MODIFICATIONS TO ELECTRICAL SHEETS

TOWN OF ADDISON, TEXAS

ADDISON ROAD IMPROVEMENTS
BELT LINE ROAD TO ARAPAHO ROAD PHASE I
ELECTRICAL MODIFICATION NOTES

DESIGNED BY: <u>G.C.</u>	PROJECT: <u>2002_102</u>	SHEET NO. <u>E-0</u>
DRAWN BY: <u>B.H. & C.</u>	DATE: <u>SEPTEMBER 2006</u>	OF <u>68</u> SHEETS

DESIGNED BY: JAC
 PROJECT: 2002102
 DRAWN BY: JAC DATE: OCTOBER 24, 2007 SHEET NO. E-5 (66)
 OF 66 SHEETS

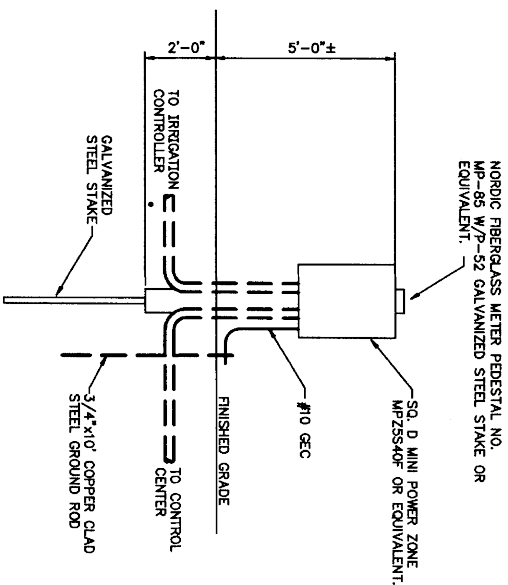
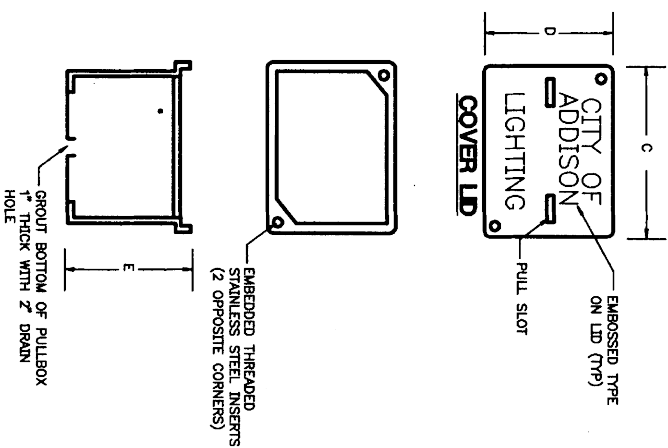
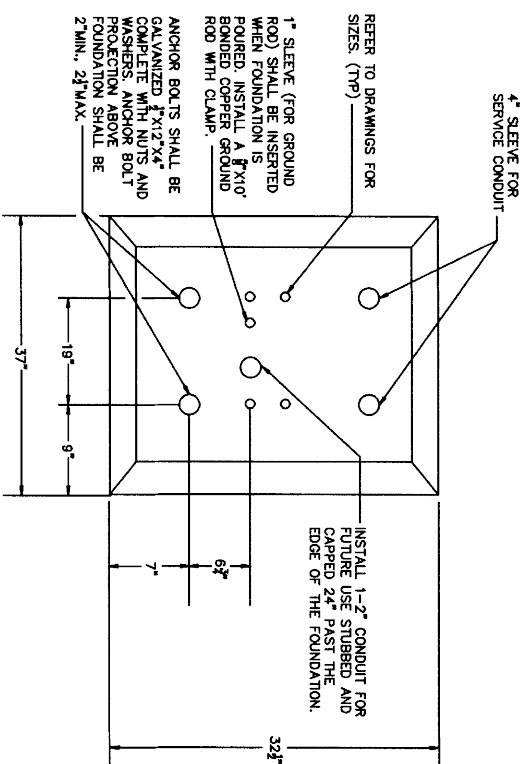
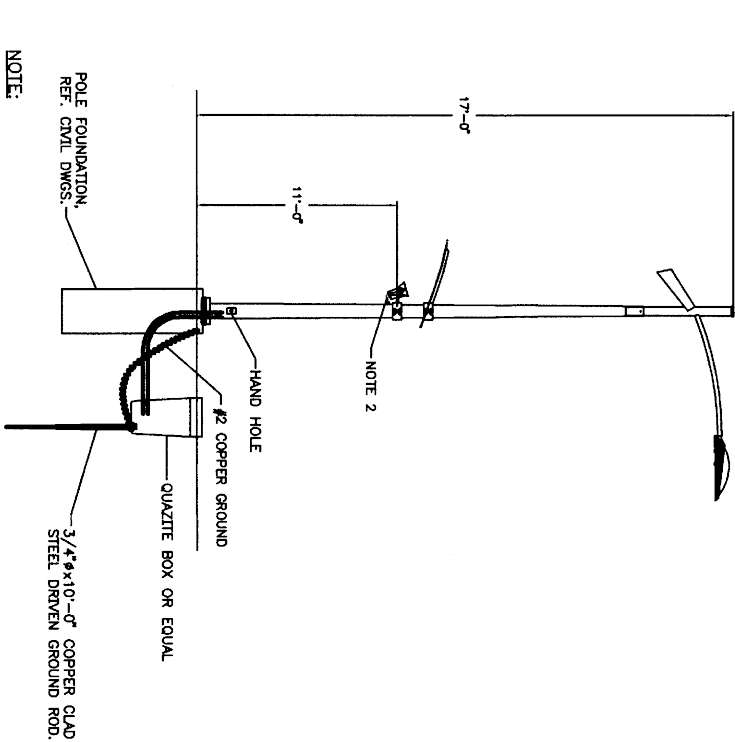
2. Change the conduit size to 2-inch.
- D. Sheet No. 66 (Drawing E-4): Roadway Lighting - Part "D"
 1. Add an additional Utility Service/Detail 2/E-5 for a total of two (2) Utility Services. One service will serve Roadway Lighting exclusively and the other service will serve Pedestrian and Irrigation Systems.

2. Currently a single feeder containing 2 #10, #10G, 3/4" C, is shown from the single service to each pullbox/light fixture. Provide an additional feeder of 2 #10, #10G, 2" C, to also loop through each pull box. One circuit will serve Roadway Lighting exclusively while the other feeder will serve Pedestrian and Irrigation Systems.

3. Change the conduit size to 2-inch.

3 ROADWAY/PEDESTRIAN FIXTURE 'SAA'
 SCALE: NONE

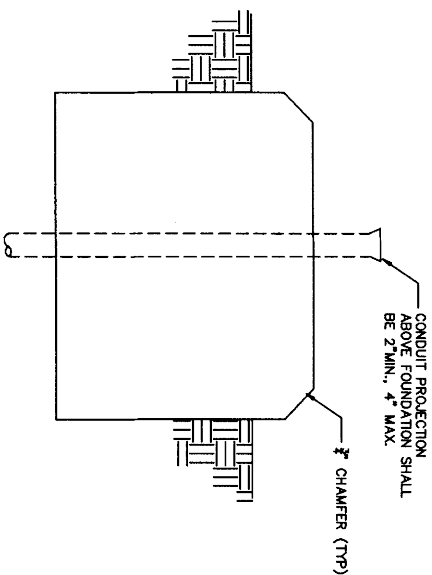
- E. Sheet No. 66 (Drawing E-5): Details.
 1. Modify detail 3/E-5 height currently indicated for the pole as 38'-0" to 17'-0".
 2. Detail (3/E-5) Fixture SAA add the following:
 "For combination roadway/pedestrian type SA fixture, the light fixture and obstruction light will both be served from the pedestrian lighting circuit and be controlled by the obstruction light photo cell."

DESIGNED BY: J.A.A.
 PROJECT: ADDISON ROAD IMPROVEMENTS
 DRAWN BY: J.A.A. DATE: CONTRACT 24, 2007 SHEET NO. E-7 (08)
 SHEETS

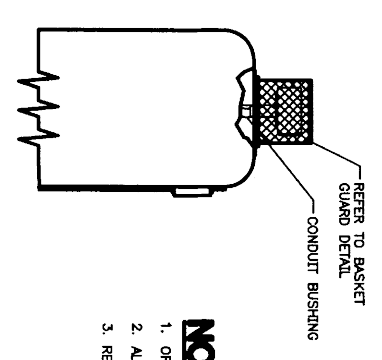
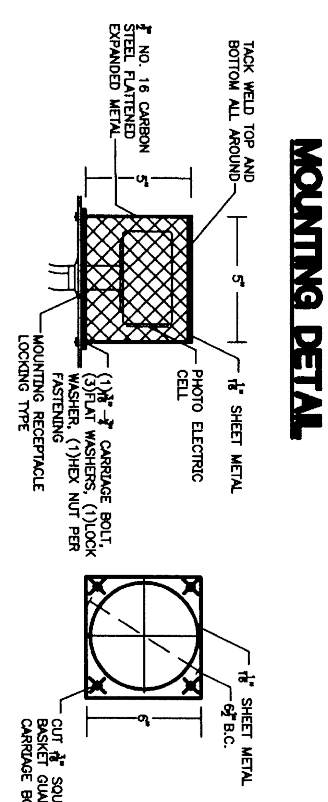
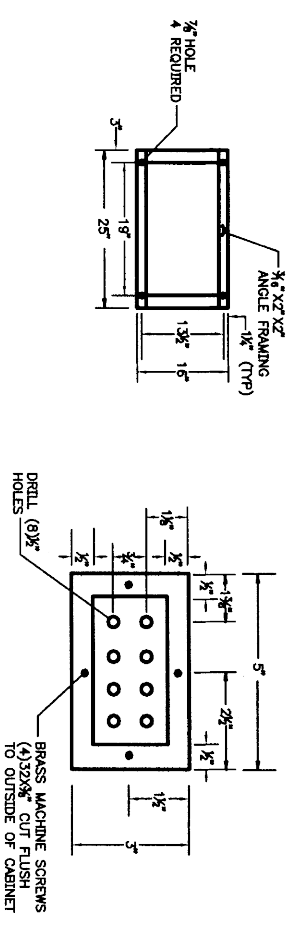
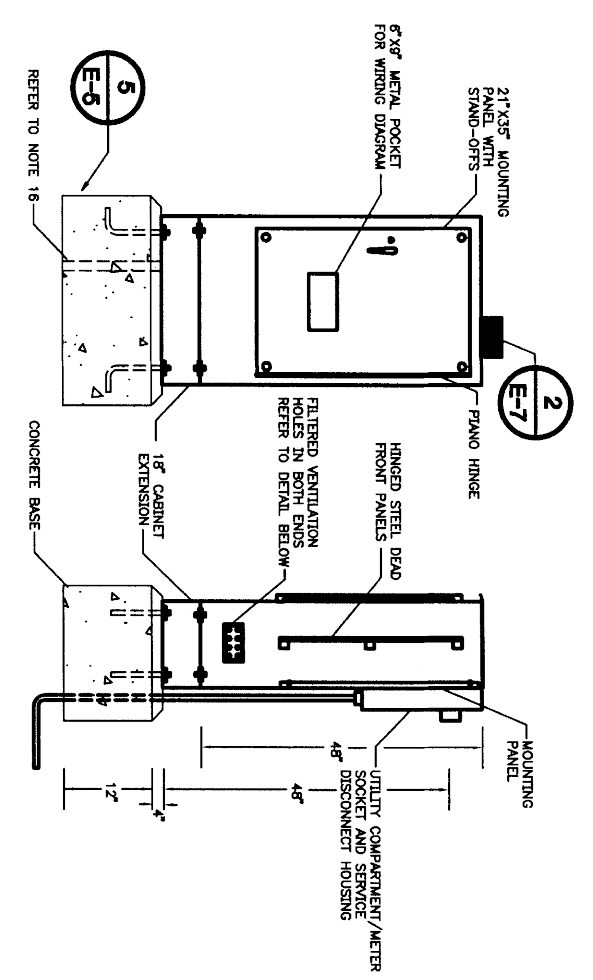
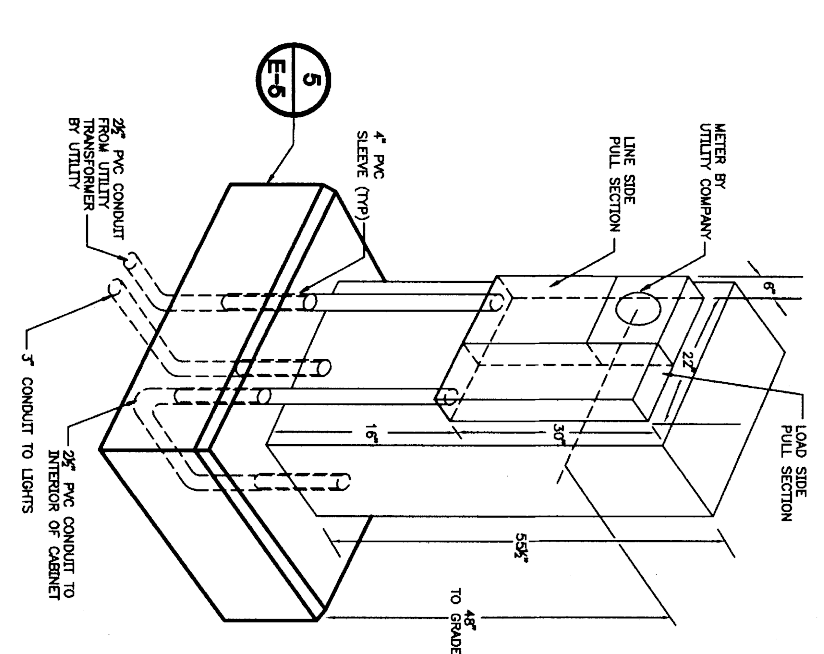
2. Add the description "photo cell" to the leader line on the detail for fixture SB to control the fixture.
- G. Sheet No. 68 (Drawing E-7): Schedules
 1. Modify Light Fixture Schedule note 4. Note should read "Similar to "SA" except 17-foot maximum height pole".

2. Add the following:
 "The poles shall be steel and the color of the top coats shall be selected by the Town of Addison. The manufacturer of the fixtures is Lumec-Schneider of Canada, local representative, 214-658-9000."
